CITY OF ALBUQUERQUE

November 1, 2022

Re: MAS Charter School
Neighborhood Impact Assessment, HT#L16D037
Report dated October 2022
Engineer's Stamp -----

The subject Neighborhood Impact Assessment (NIA) received October 20, 2022, has been reviewed by the City of Albuquerque Planning Development Transportation Section. The City request that the NIA be resubmitted with an Engineer seal for final approval.

Yale Boulevard Conceptual Drawings for West
Loop Alternatives

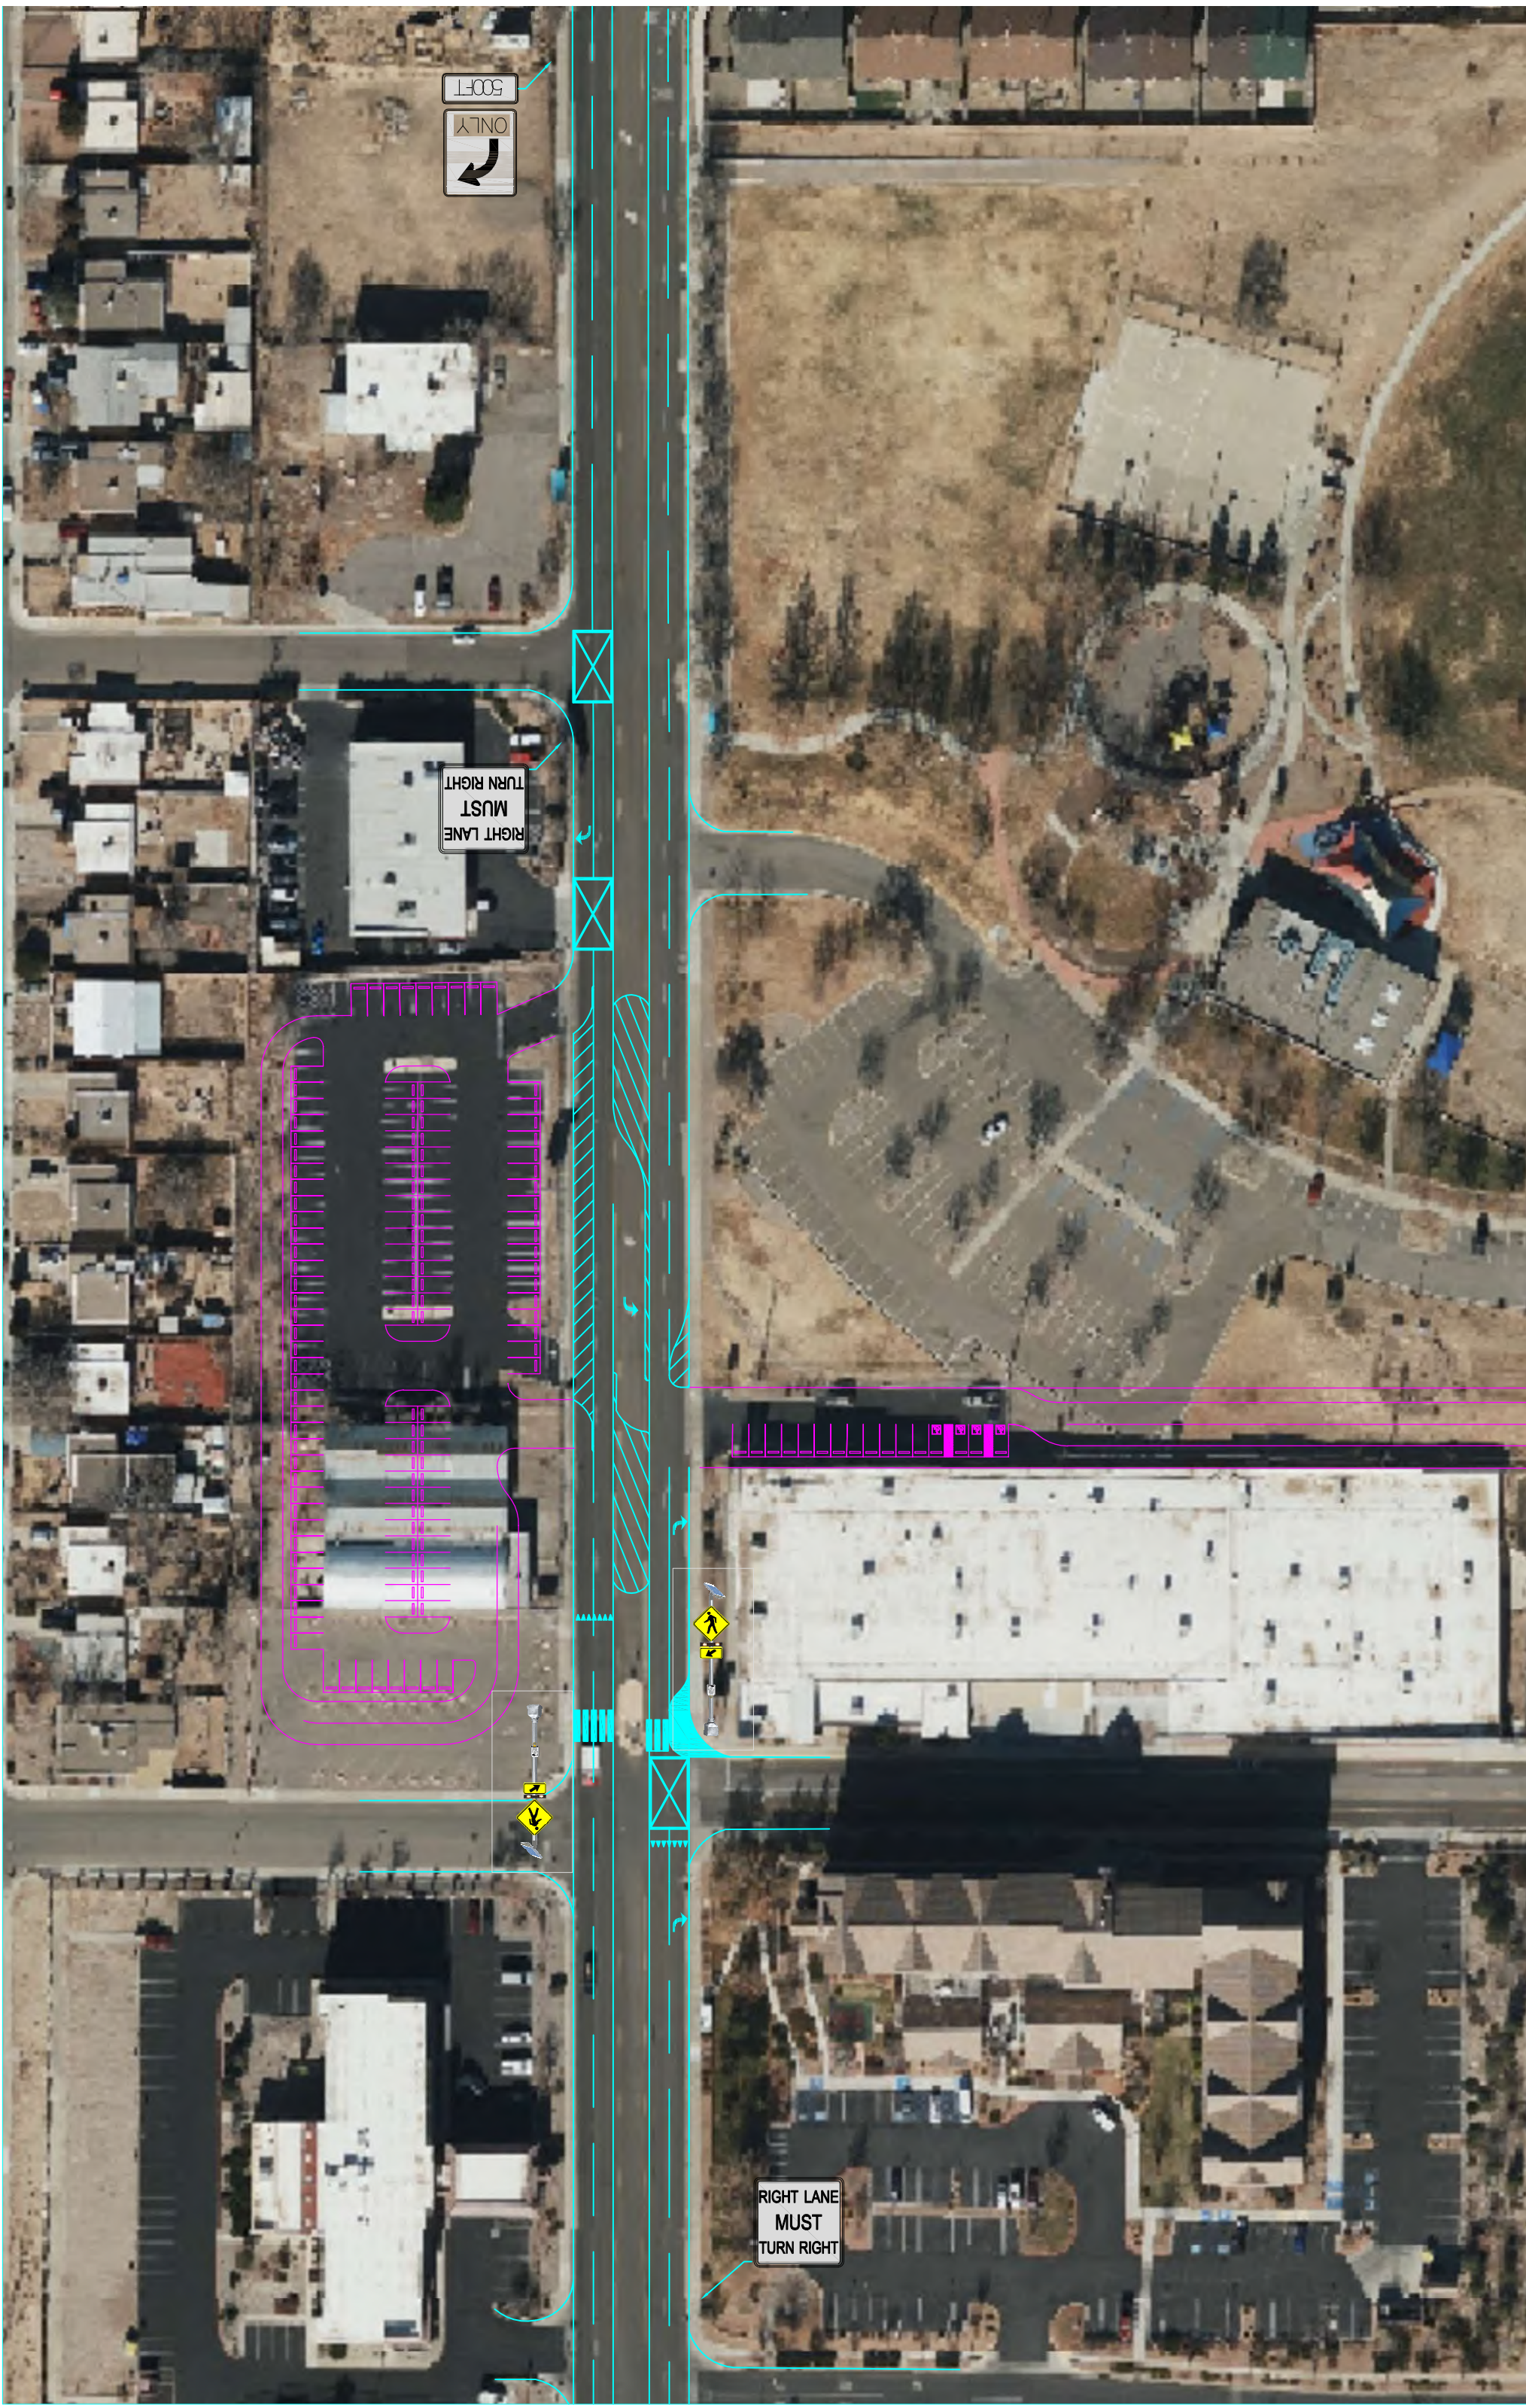
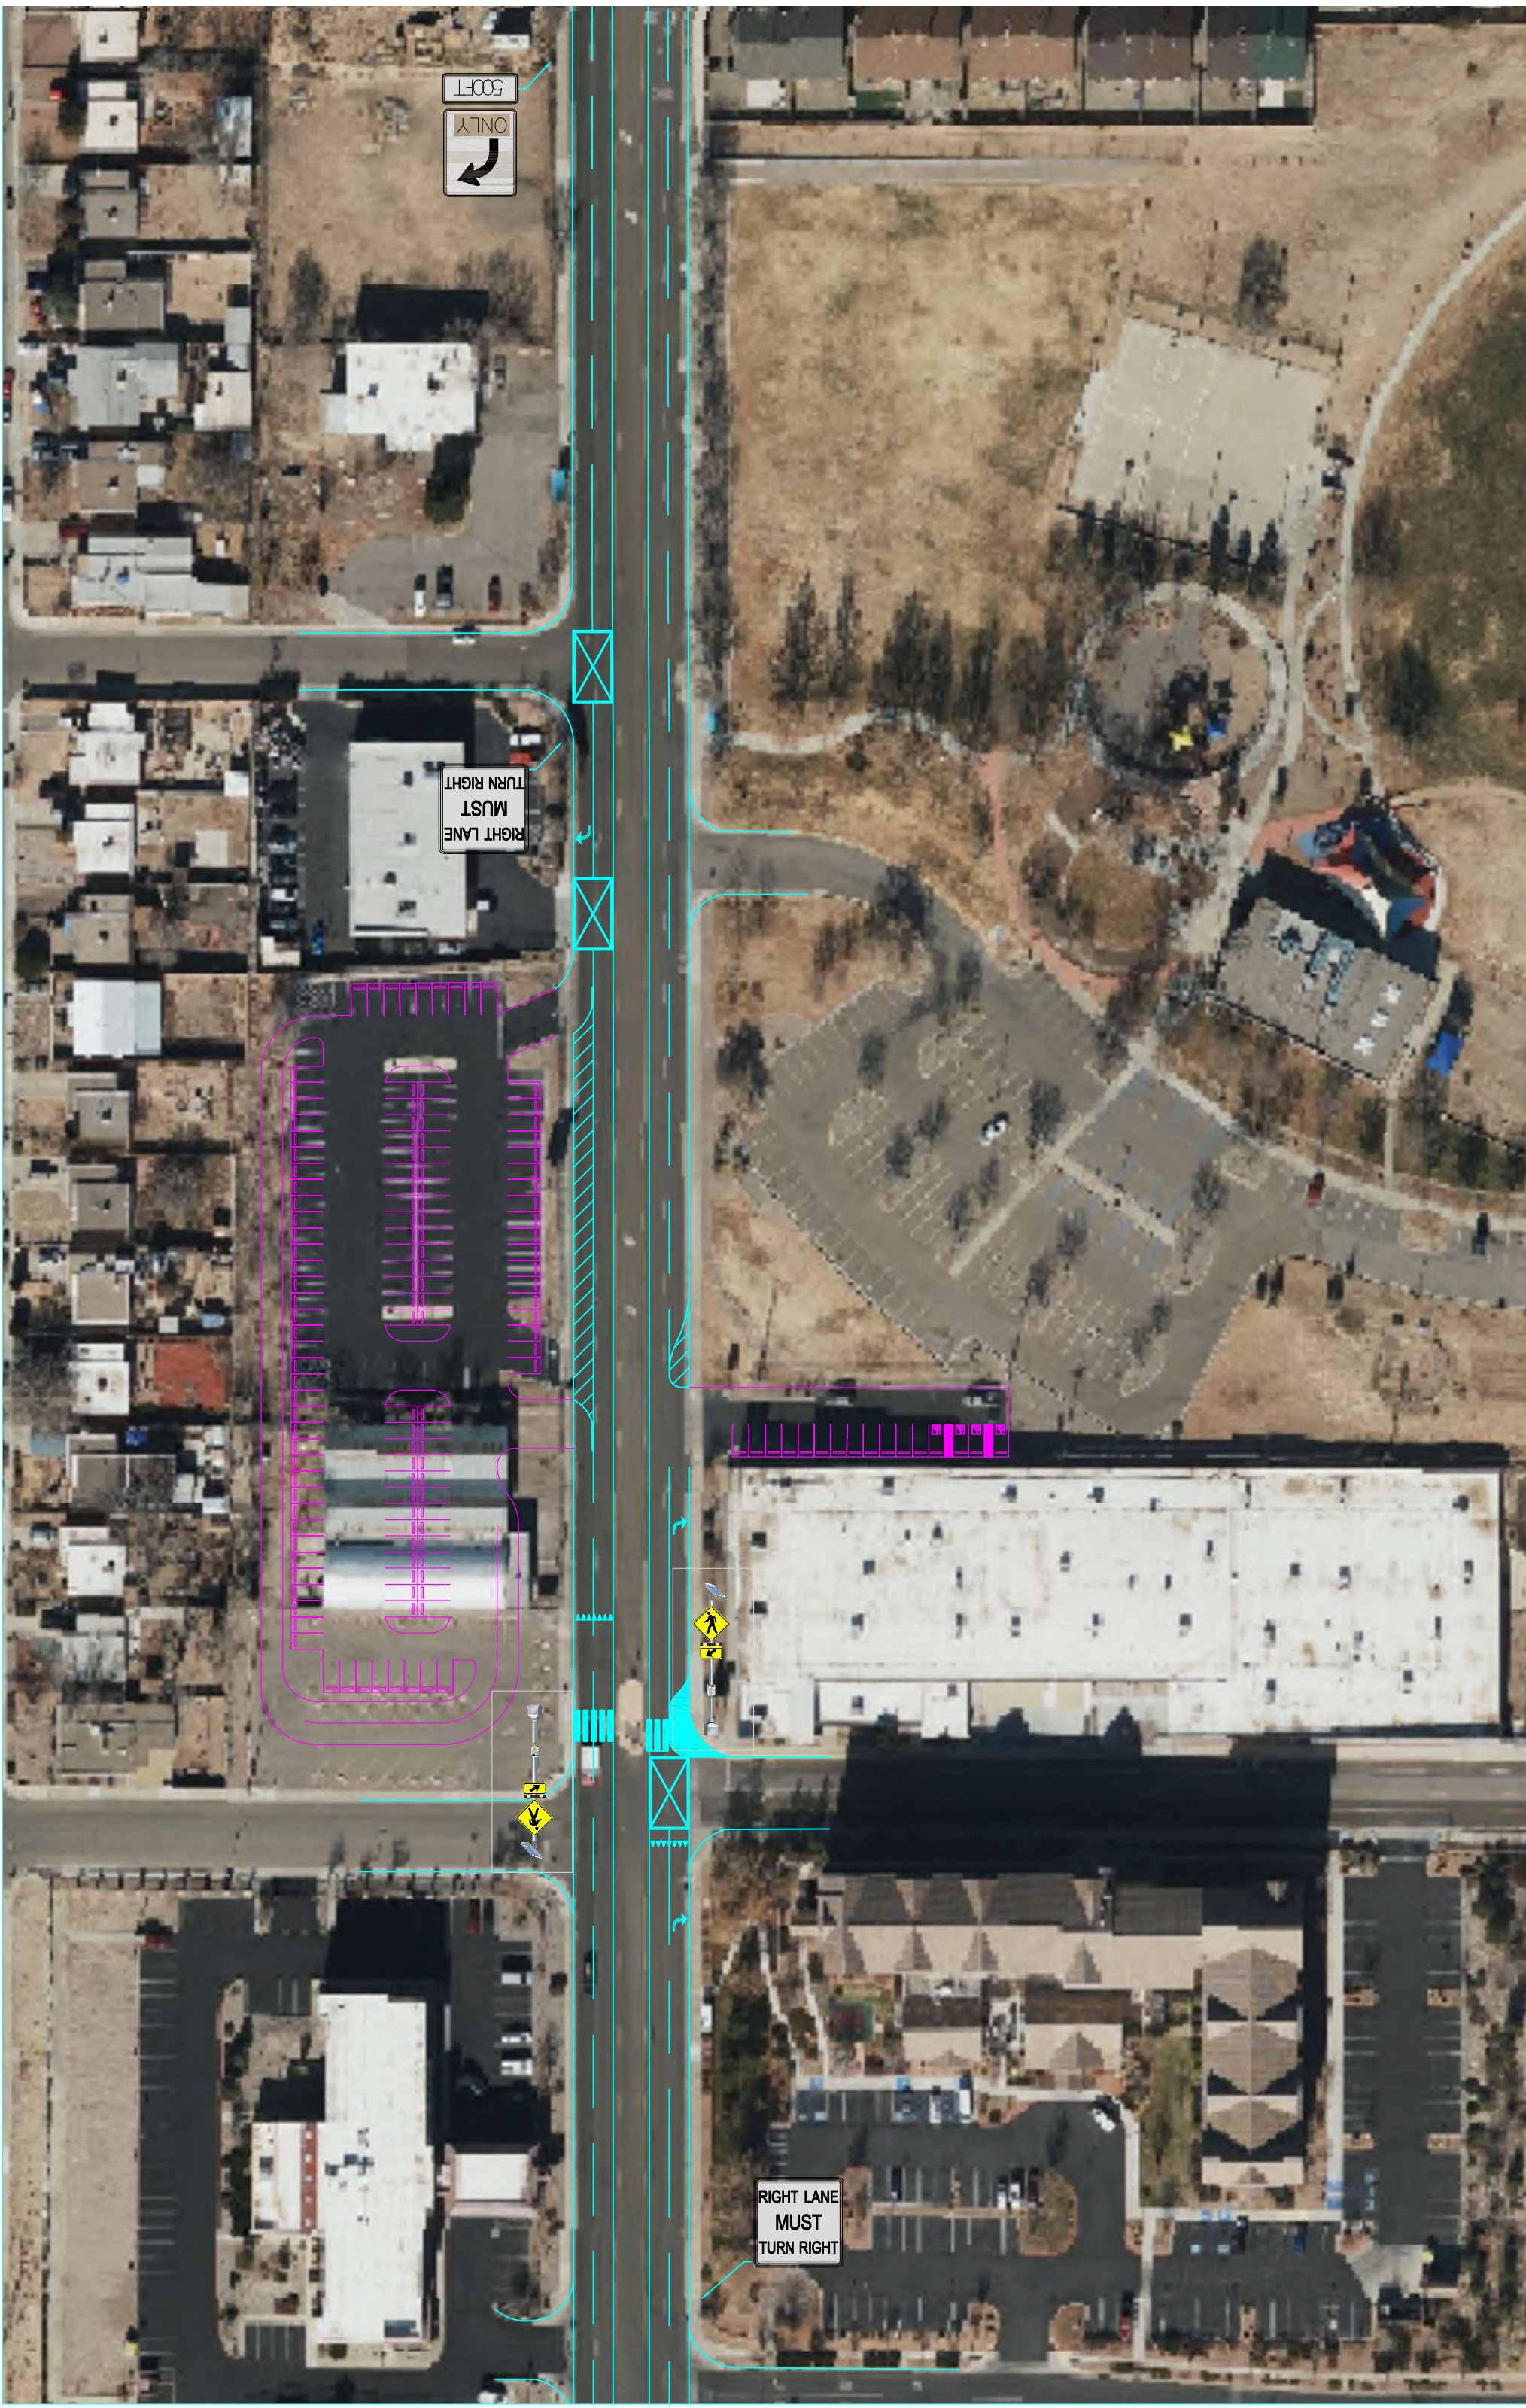
- Blocking the business's driveway, north of Driveway 1, is prohibited. Do Not Block Intersection pavement markings shall be applied, communicated to parents, and firmly enforced.
- An exclusive right-turn lane should be striped on northbound Yale Boulevard between Ross and International Avenues per the CABQ DPM for the West Loop alternatives.
- Access to the site is maintained via the drop-off/pick-up operations map provided in the report.
 - Driveway 1 - right-in only
 - Driveway 2 – right-out only
 - Driveway 4 – right-out only
- Stripe a through/right turn lane on Yale Boulevard for Driveway 2 egress.

- Install plastic bollards between the turn and through lanes at Driveways 1 and 2 to communicate the right-in, right-out access of these driveways.

- For the Community Center Loop establish a median treatment to restrict left-turns from northbound traffic to access Driveway 2 while allowing southbound traffic to complete left-turns to access Driveway 3.
- For the Community Center Loop, auxiliary right-turn lanes are established on Yale Boulevard for Driveways 1 and 3.
